ARUN DISTRICT COUNCIL

Reference: **AW/248/18/HH**

Front two storey extension to 13 Gossamer Lane, Aldwick PO21 3AT

DRAWING BLOCK PLAN	SCALE 1/500
DATE: JULY 2018	
DRAWN: T. Murray	
DRAWING: 18/38/3	REVISION:

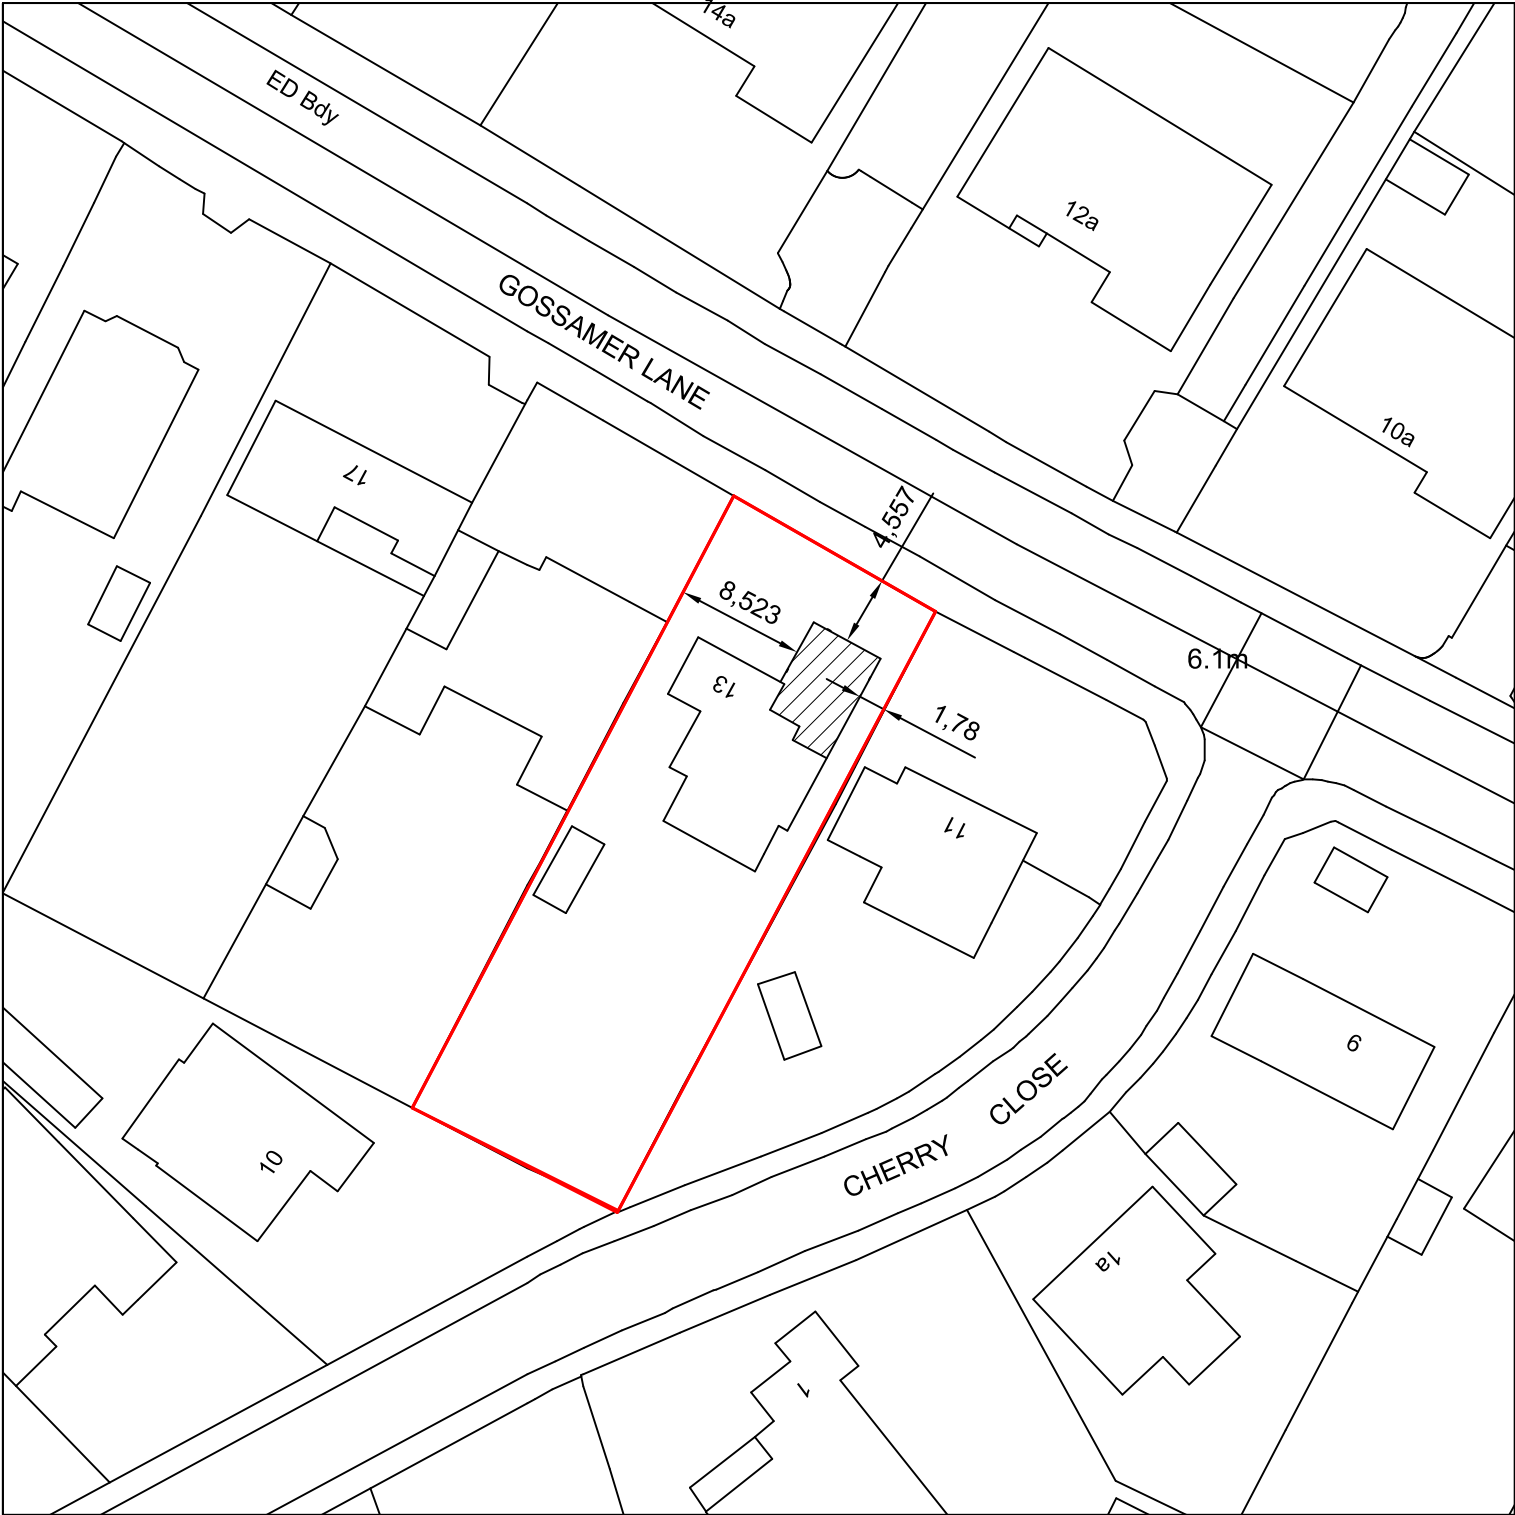
- 1 The proposed extension will far exceed the building line of existing properties in the road and will effectively be in front of my house, therefore being visually dominant.
